From: Michael Eastham
Sent: 01 February 2018 10:00
To: Planning.Responses
Subject: RE: LU/121/17/RES - Main Avenue Landscaping etc.

I do note that condition 7 of the outline consent does refer to the *overall* scheme, albeit requiring each phase to comply with the terms of the condition as-and-when submitted. Therefore, my comments here (and below) solely reply to the Main Avenue running E-W through the first part of the reserved matter application submitted under LU/121/17/RES.

Please could I have your comments on the attached, amended Landscaping plan for Phase 2 of the residential development at North Littlehampton Strategic Development Area.

Tree Planting Details LA108

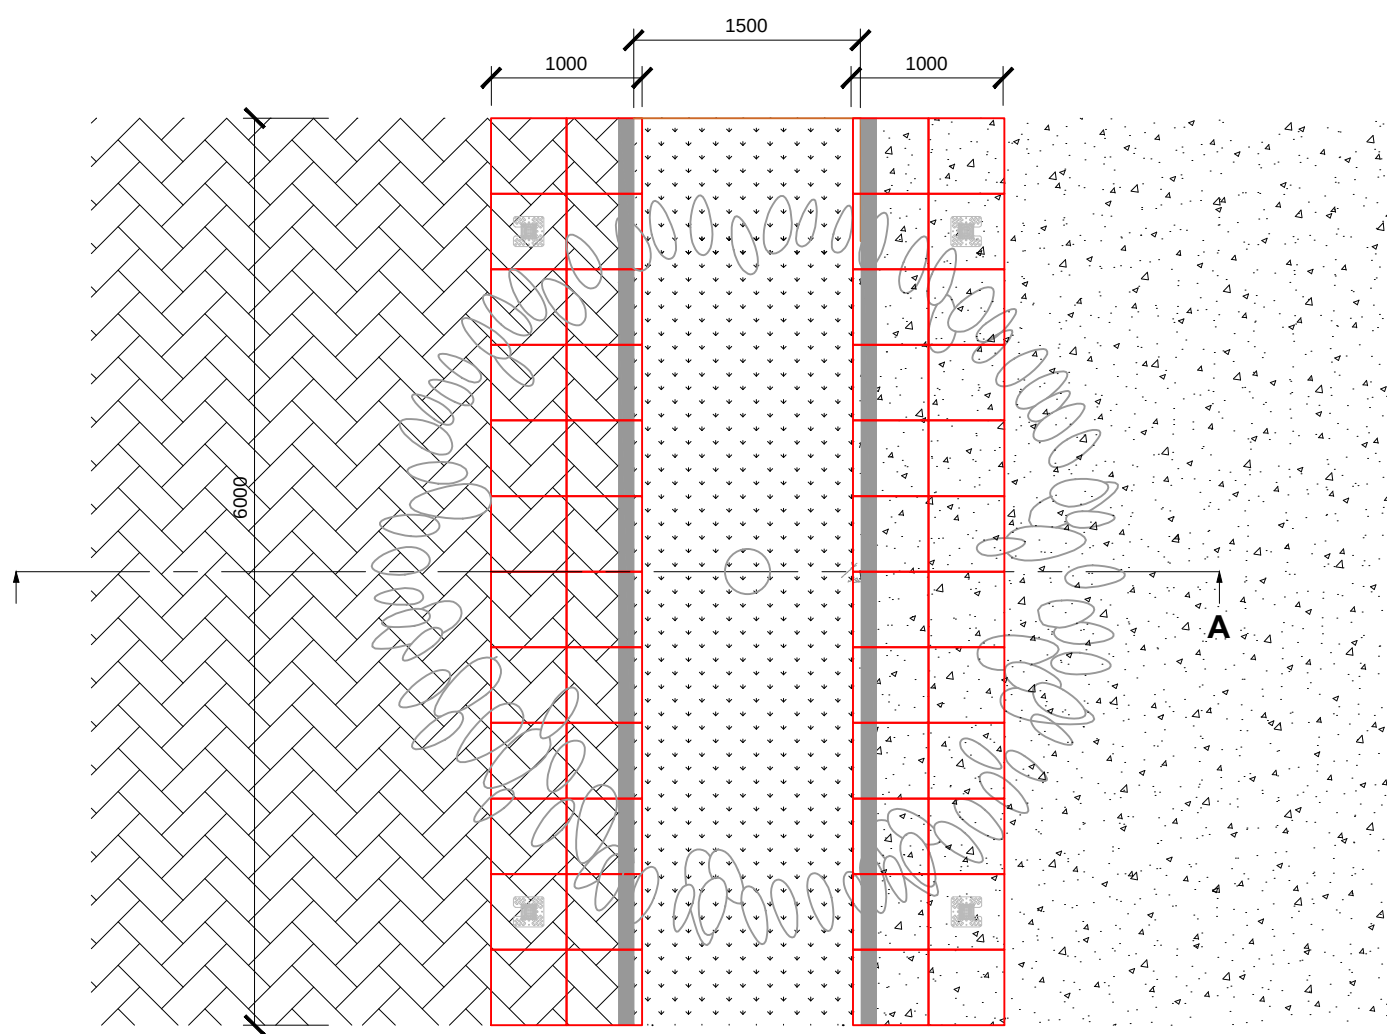
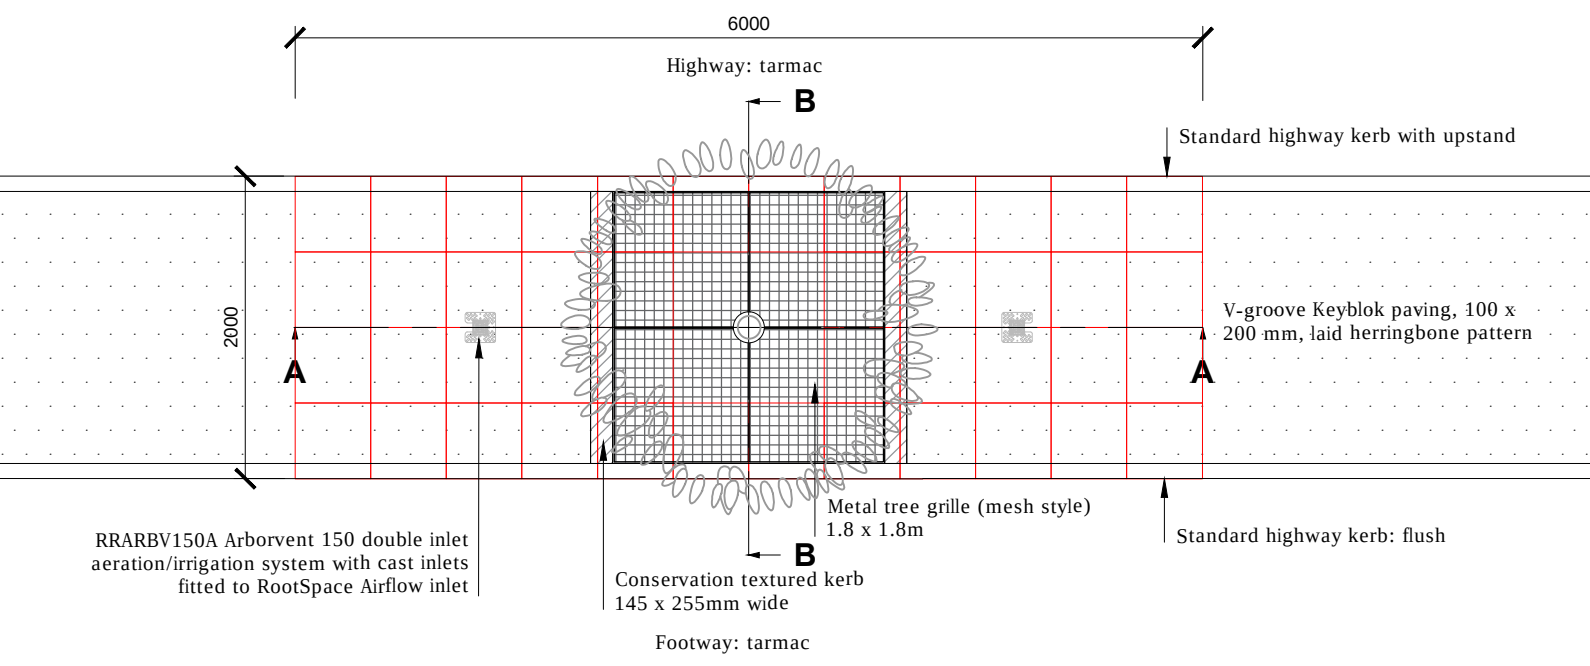
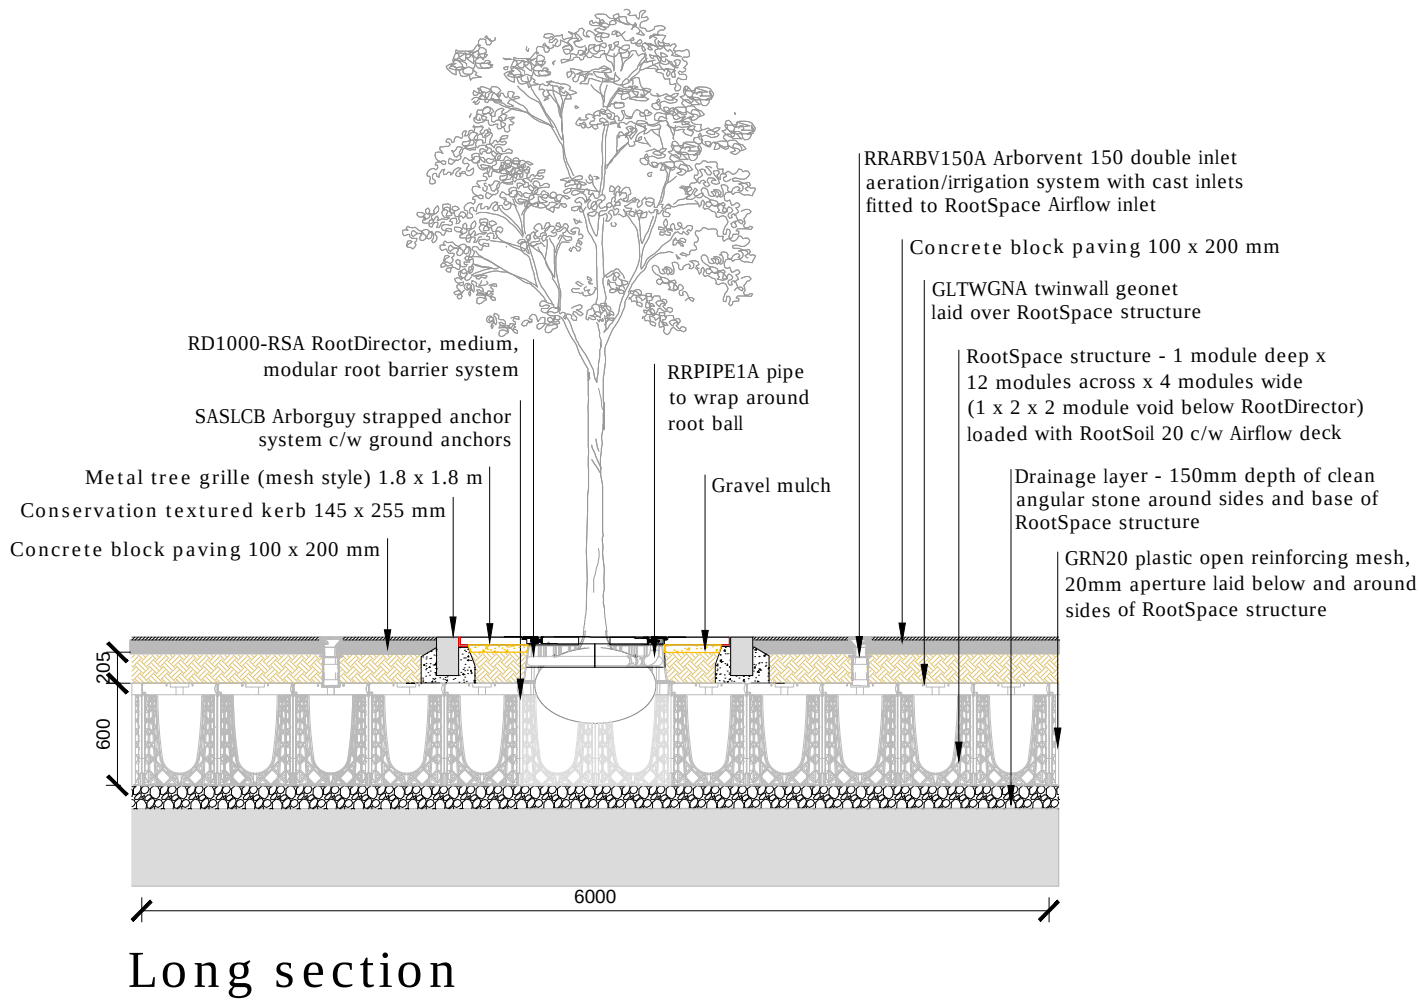
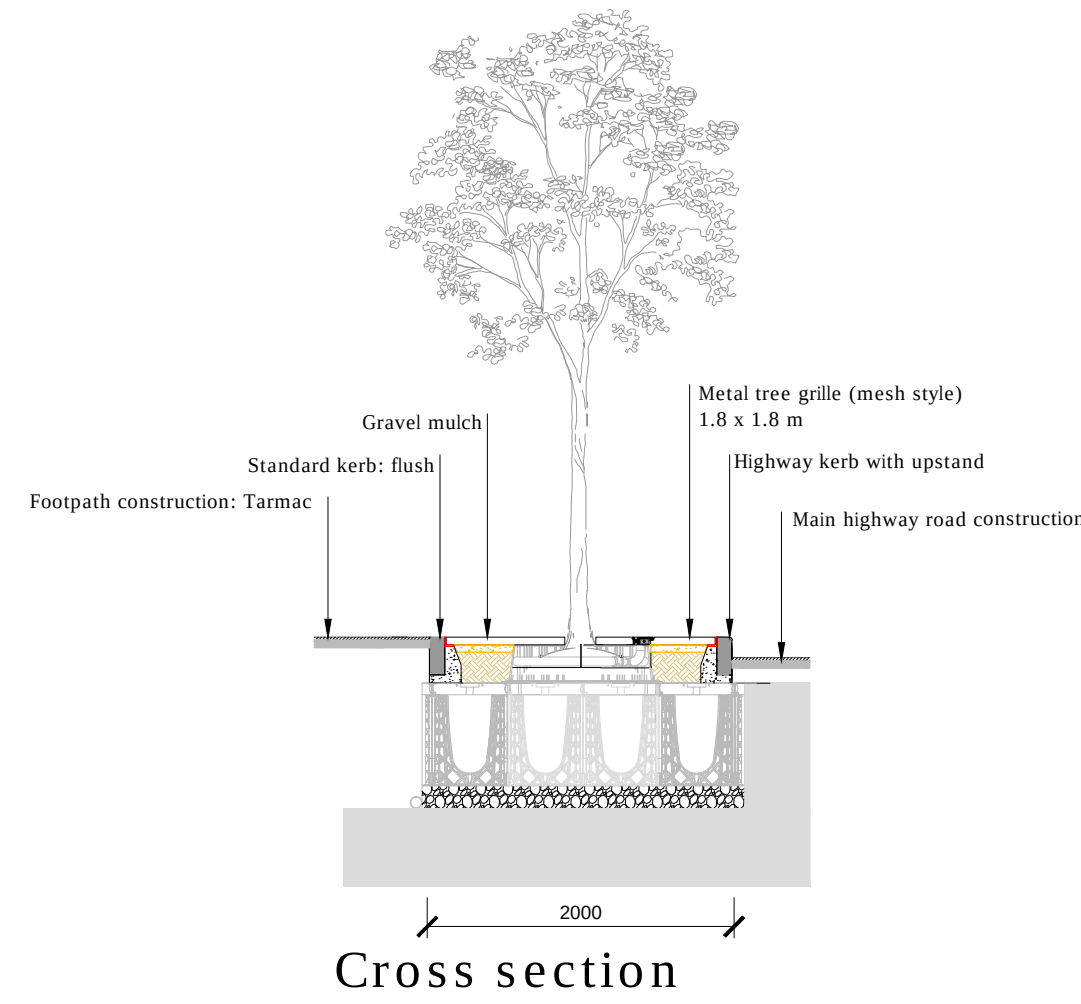
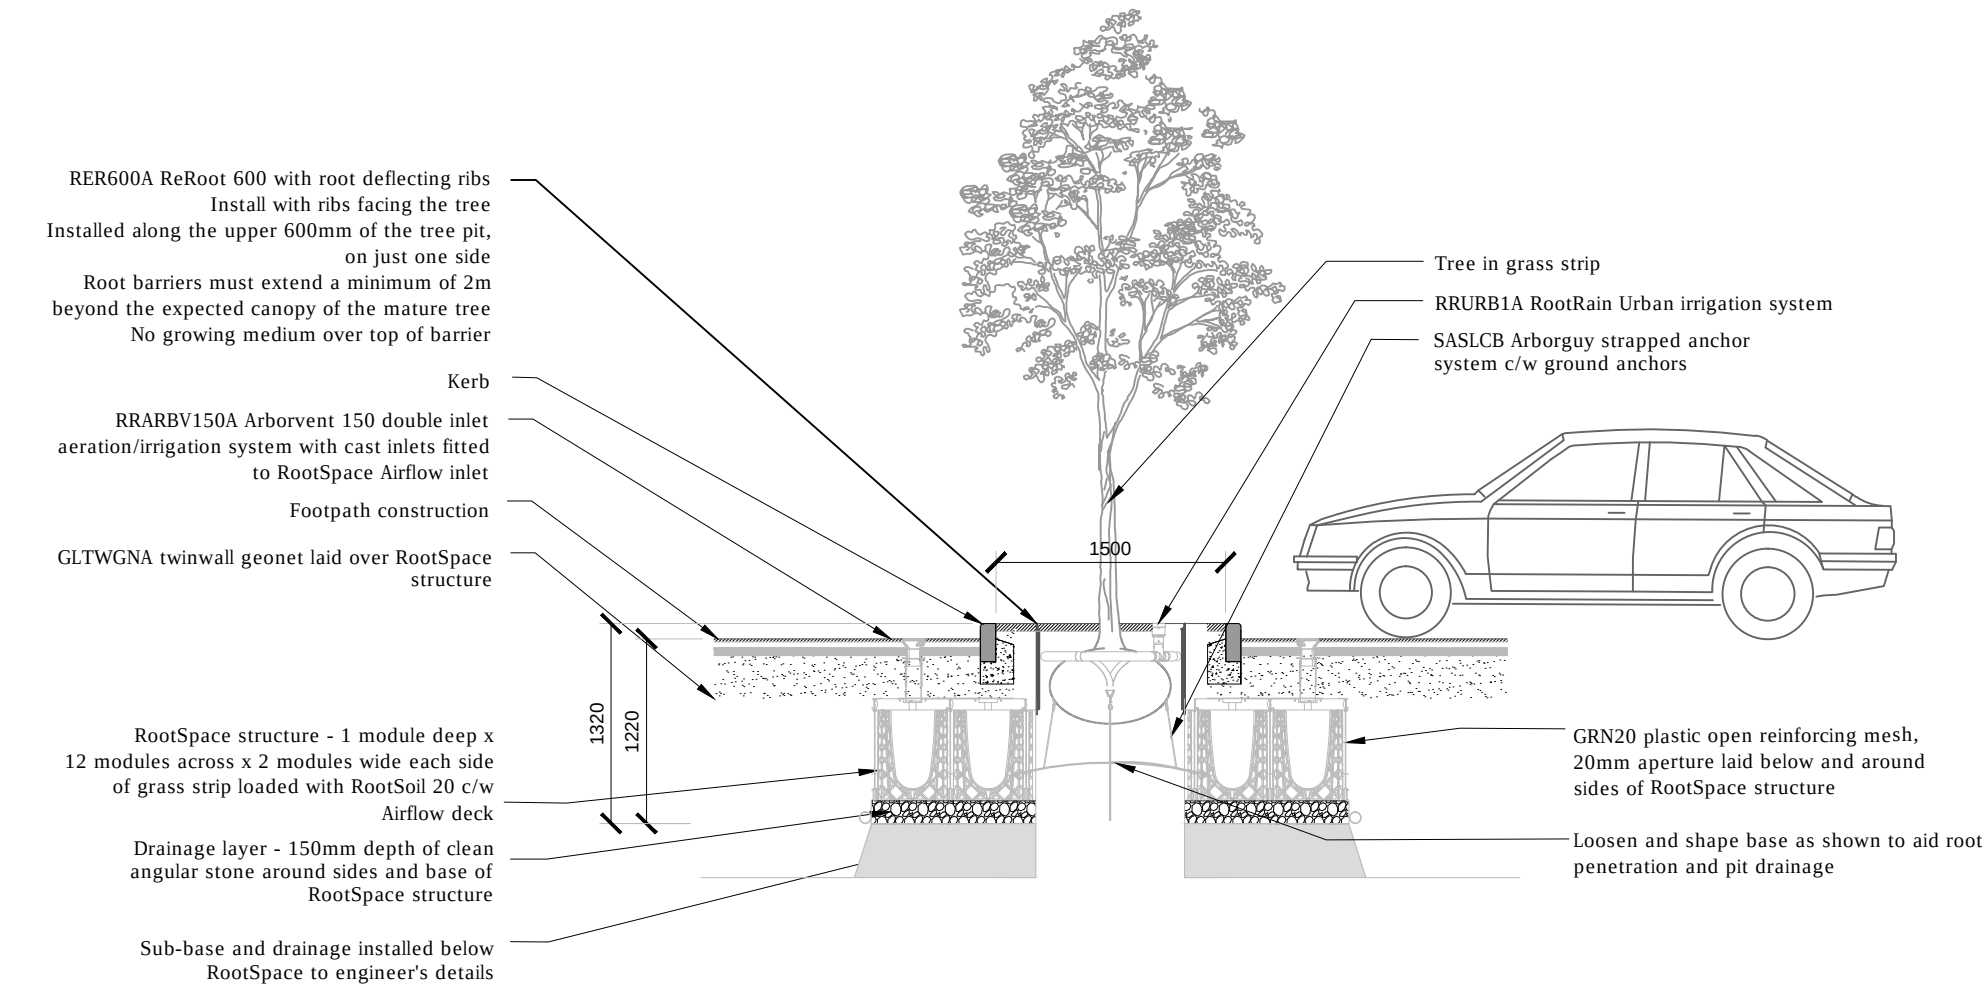
- 1. Tree types** – must be clean (and narrow) stemmed up to 2.4m with no growth beneath when mature (to provide clearance for cyclists and pedestrians underneath).

- 2. Street lighting** – Street lighting design and positions need to be considered carefully so as to not be obscured by tree canopies etc.
- 3. Verge/hard landscaping areas** – A continuous verge would still be advantageous/preferred for tree root spread. Hard landscaping in-between trees can attract weeds etc. and might require additional maintenance (for which an additional commuted sum might be required). If used, Keyblok paving is acceptable to WSCC.

- 4. Services** – must not run in verges nor hard landscaping areas where trees are proposed, nor roads (put them in footways/cycleways).
- 5. Road Safety Audit (RSA)** – A Stage 2 RSA will be required at detailed design and/or S38/278 stage.

- 6. Fencing in verge or hard landscaping areas** – this should not be provided for safety and maintenance reasons.
- 7. Tree pits** – Design details of tree pits must be agreed at the detailed design/S38/278 stage prior to installation.

- 8. Commuted payments** – Will be required for tree and pit maintenance (will be worked-out at detailed design stage).
